STATE OF NORTH CAROLINA
DEPARTMENT OF TRANSPORTATION

Subject: **Request for Modification to the Regional General Permit Number 31, Section 401 Water Quality Certification, and Neuse Buffer Authorization for Improvements to Existing I-440 Beltline, from south of SR 1313 (Walnut Street) to north of SR 1728 (Wade Avenue), Wake County. WBS 35869.1.2. TIP U-2719**

Explanation of Permit Impact Site Modifications Being Requested

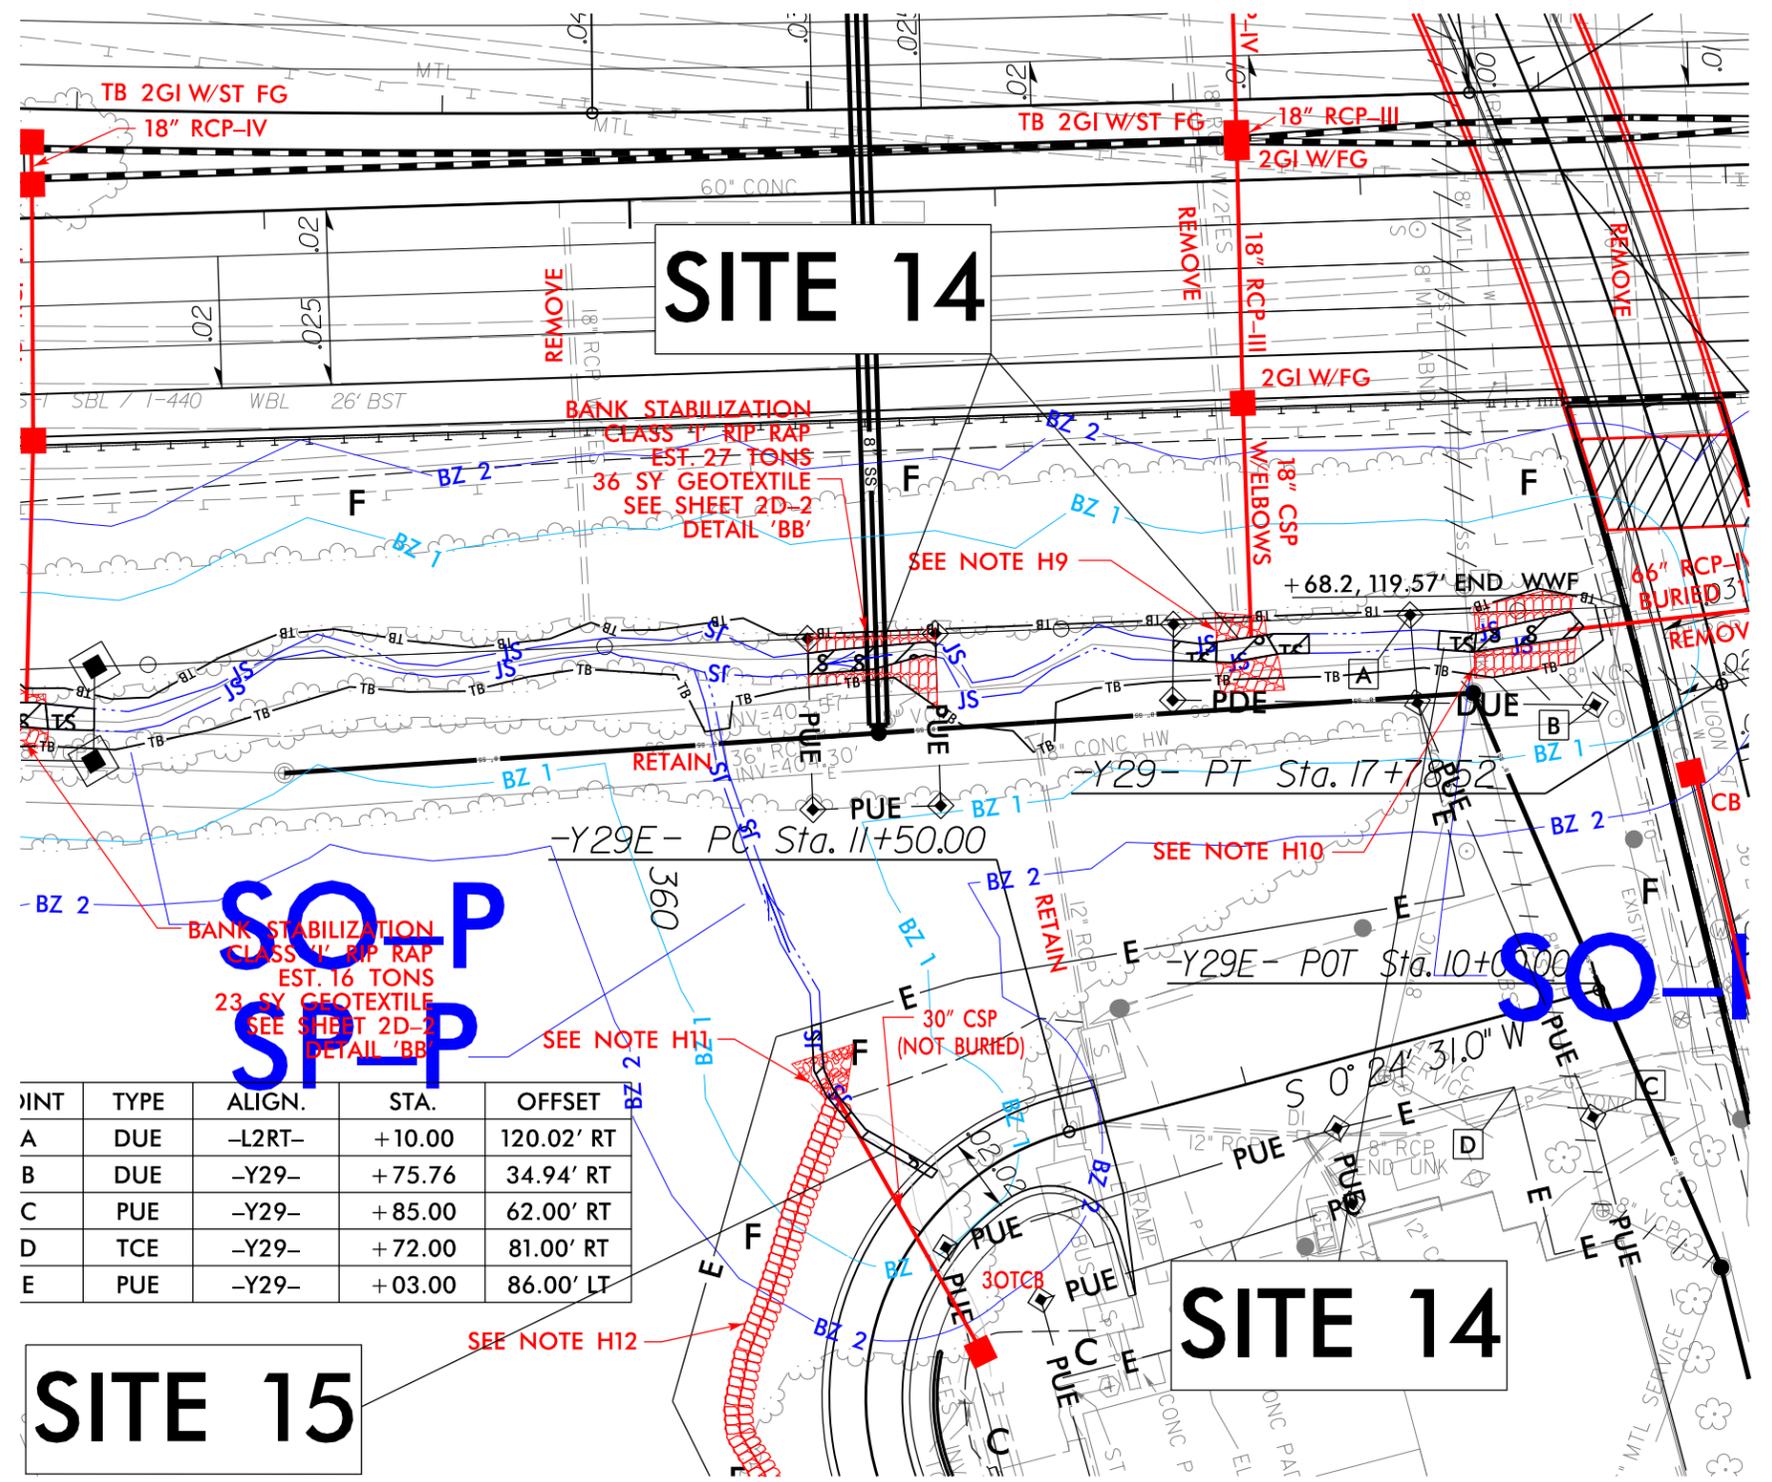
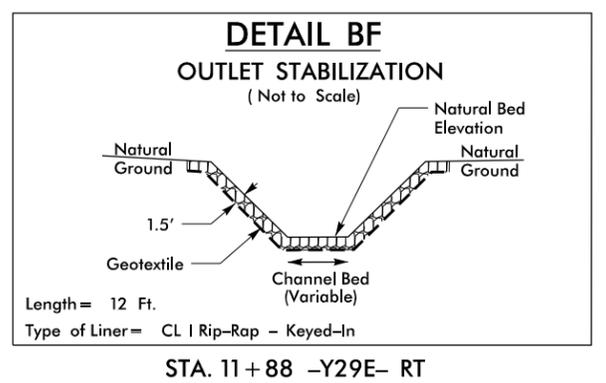
Site 14 (Sheet 18/18A) – Site 14 has an increase in permanent stream impacts and allowable buffer impacts due to a sewer line which will be bored under I-440. The increase in permanent stream impacts is due to bank stabilization being installed according to the utility recommendations. Bank stabilization impacts result in an additional 35 lf of permanent impact. Buffers will also be impacted by installation of the bank stabilization resulting in an additional 4,075 sq ft of impact in Zone 1 and 1,396 sq ft in Zone 2. This makes the total allowable impact in Zone 1 10,921 sq ft and Zone 2 is 2,780 sq ft for Site 14.

PROJECT REFERENCE NO. U-2719	SHEET NO. 28
RW SHEET NO.	
ROADWAY DESIGN ENGINEER	HYDRAULICS ENGINEER
<b>DOCUMENT NOT CONSIDERED FINAL UNLESS ALL SIGNATURES COMPLETED</b>	
 Gradient, PLLC 127 W. Chatham St., Cary, NC 27511 N.C.B.E.L.S. License Number: P-1875

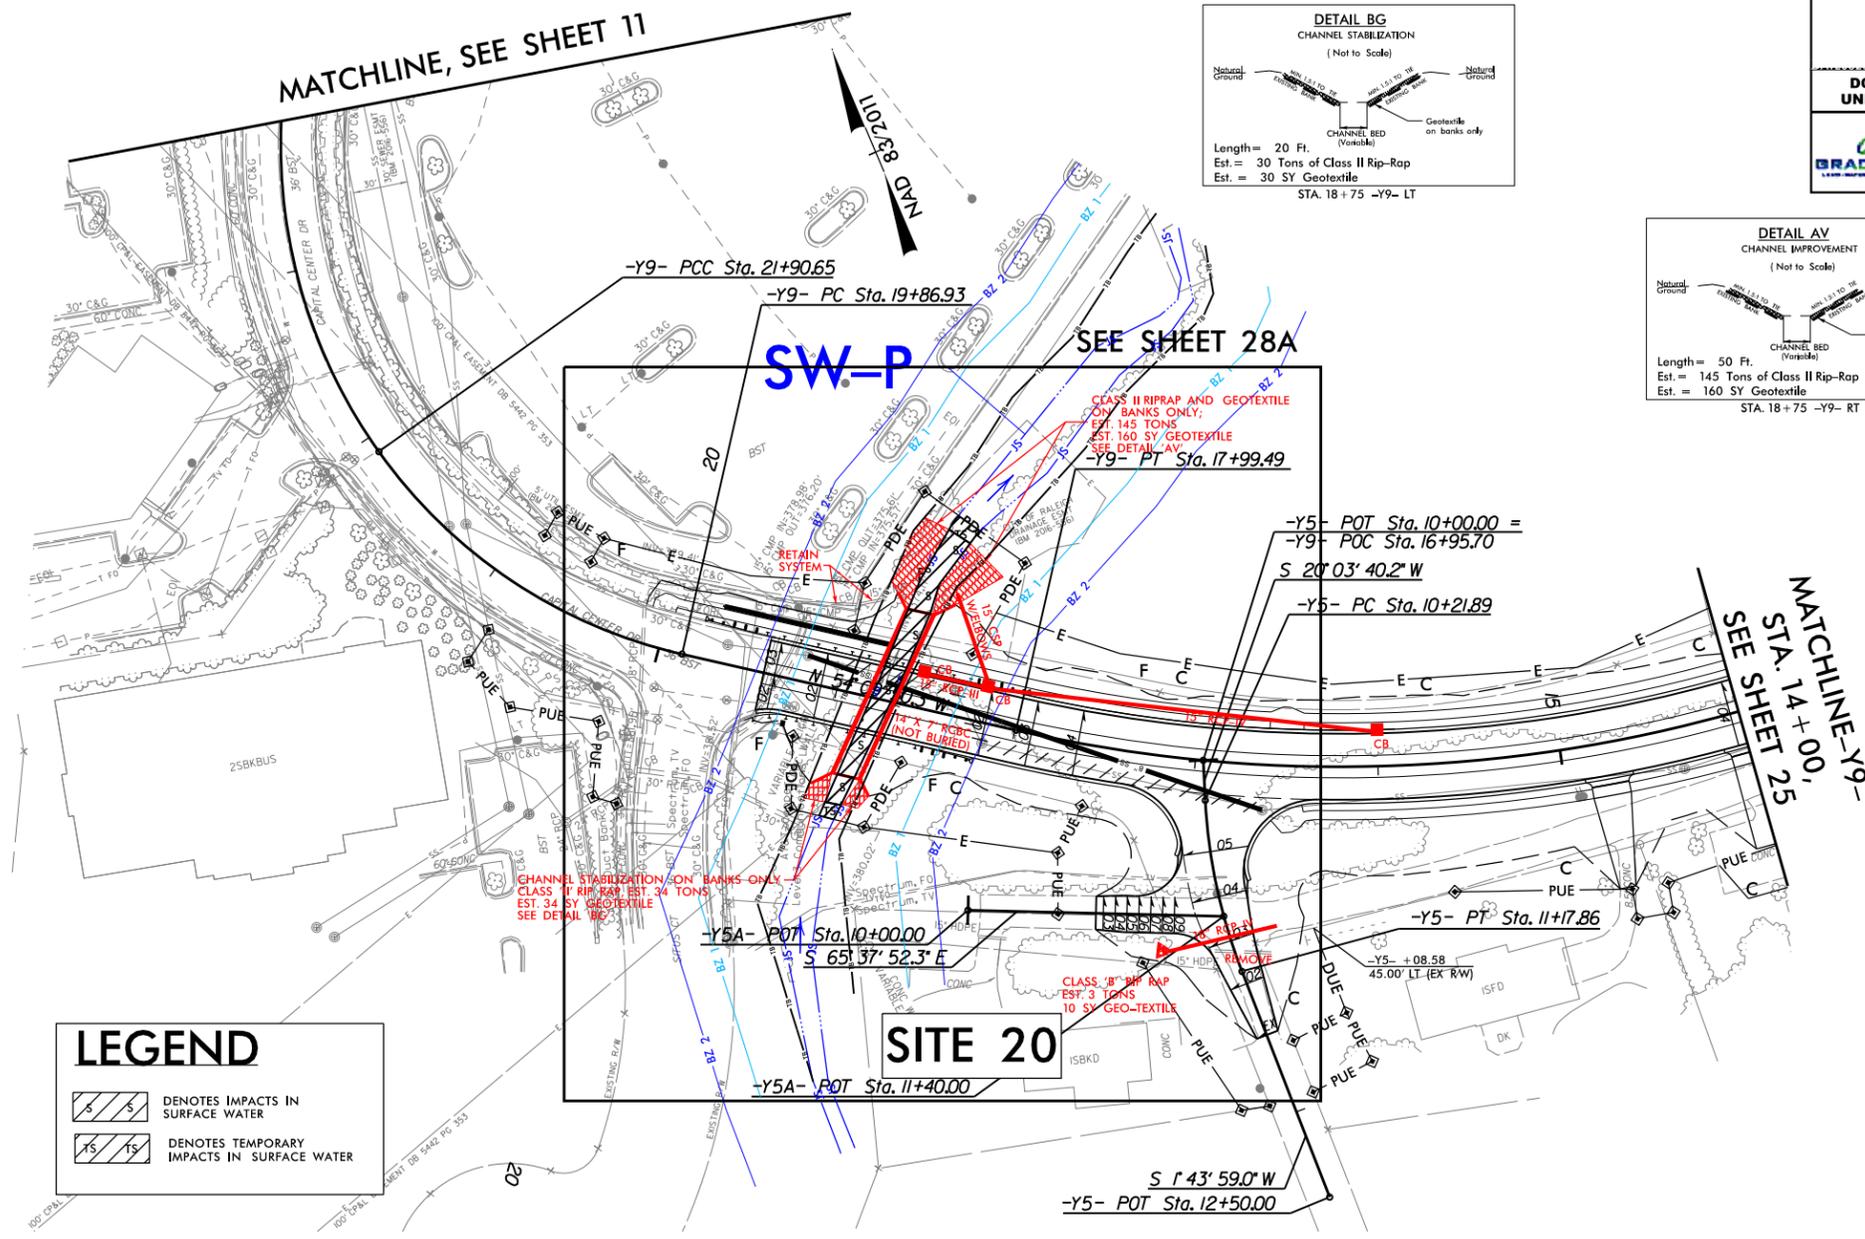
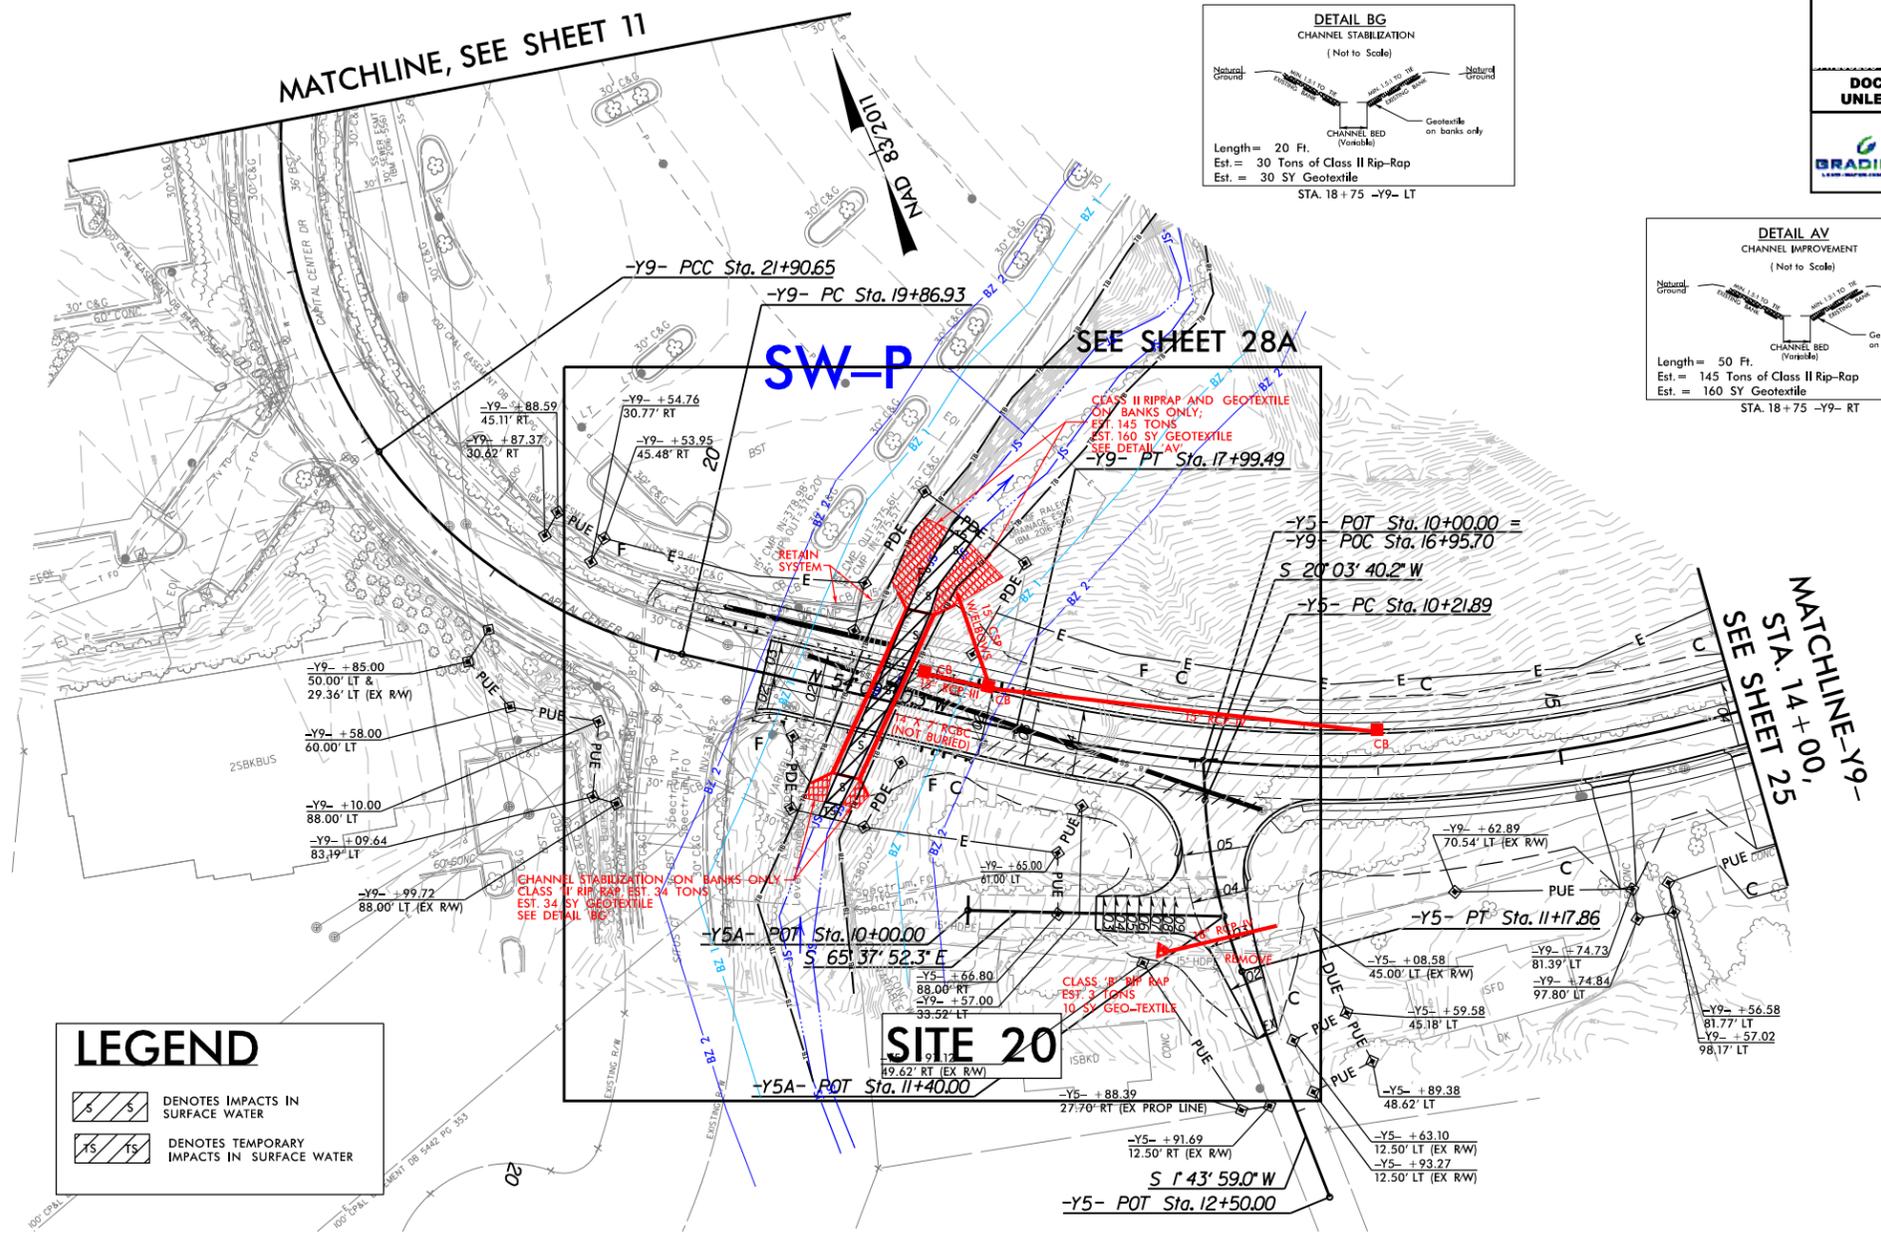
Site 20 (Sheet 28) – Site 20 impacts changed as a result of the final design of the 14'x7' RCBC in which the culvert length was increased slightly from preliminary plans and a shift in the PDE and easement due to utilities and constructability needs. The culvert length resulted an increase in permanent impacts by 6 lf for the RCBC and by 15 lf for bank stabilization. The temporary impact at this site was reduced by 11 lf. There will be a total of 98 lf of impact due to the RCBC, 65 lf of bank stabilization, and 18 lf of temporary stream impact at Site 20.
